Rezoning Transportation Analysis

Petition Number: 2021-079

From: Brandon Brezeale, PE

Transportation Summary

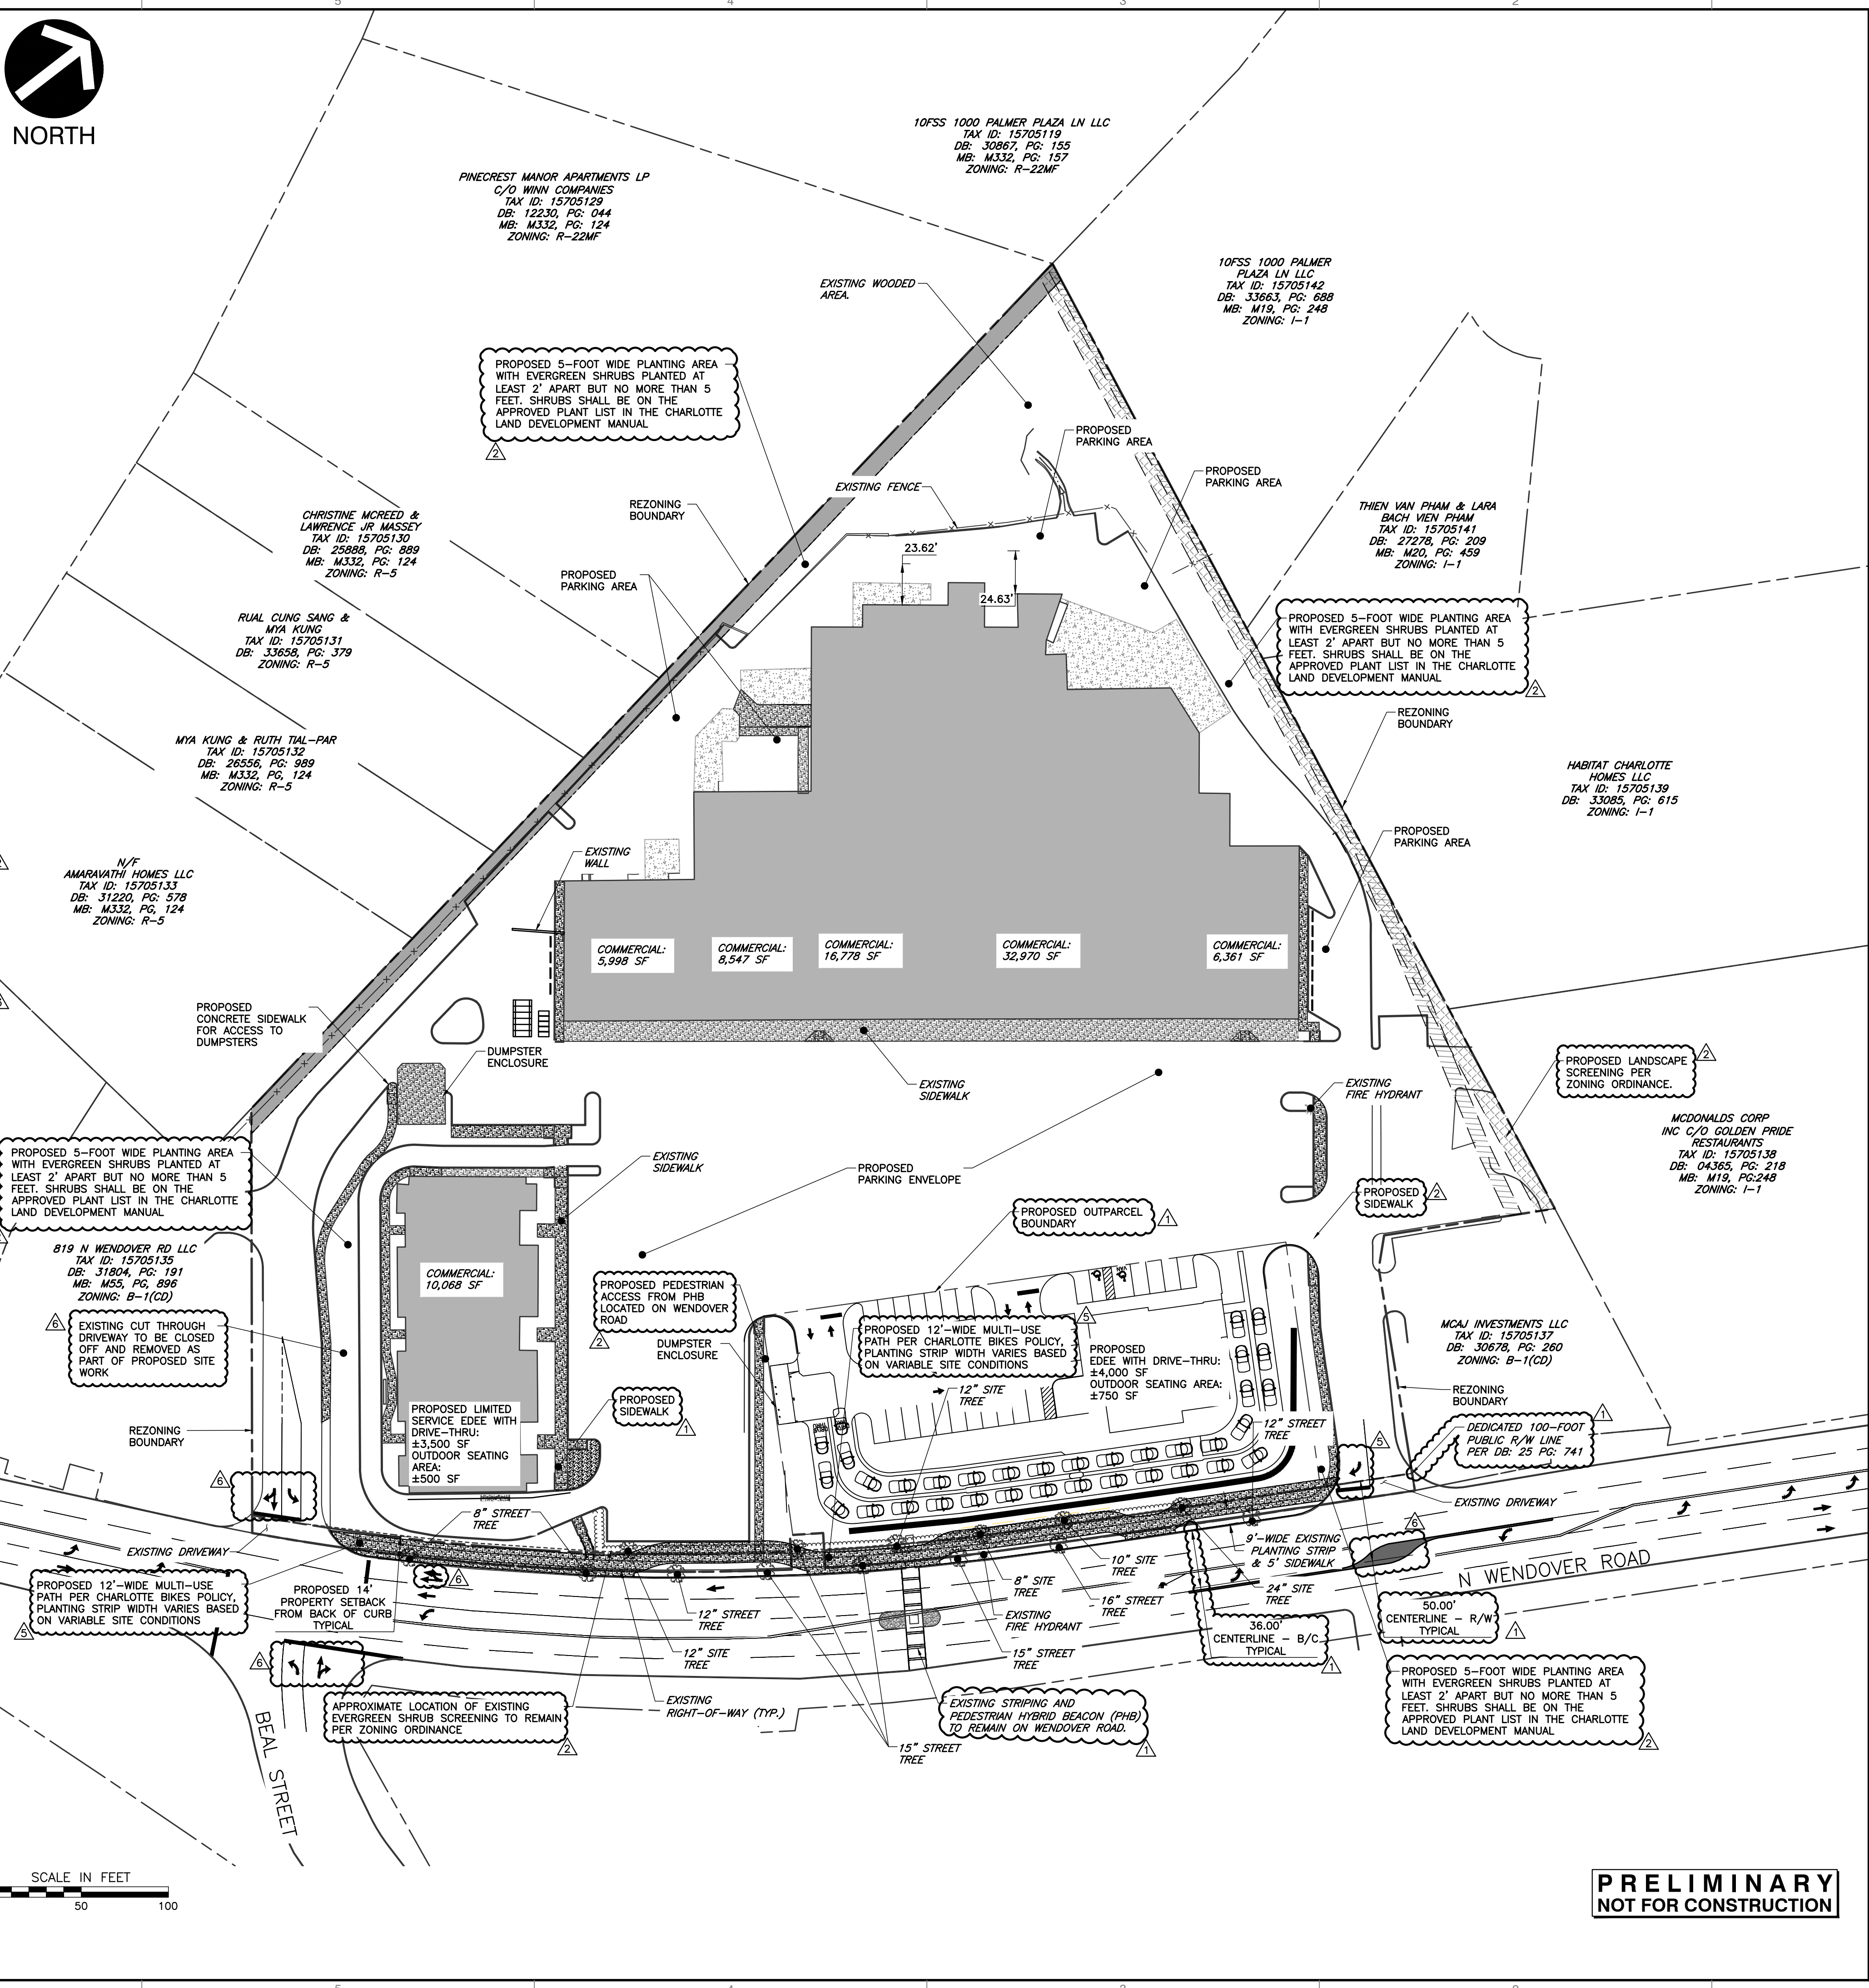
Site plan revisions are needed to commit to the installation of a raised concrete median at Access 2 to enforce a directional crossover. CDOT and NCDOT to enforce during the permitting phase. (4/12/2022)

- Curblines:** The proposed zoning district has a setback measured from back of the existing or proposed future curblines.
 - North Wendover Road:** The future location of curb and gutter is in its existing location.

Label and dimension the curb and gutter from the centerline for each road on the site plan.
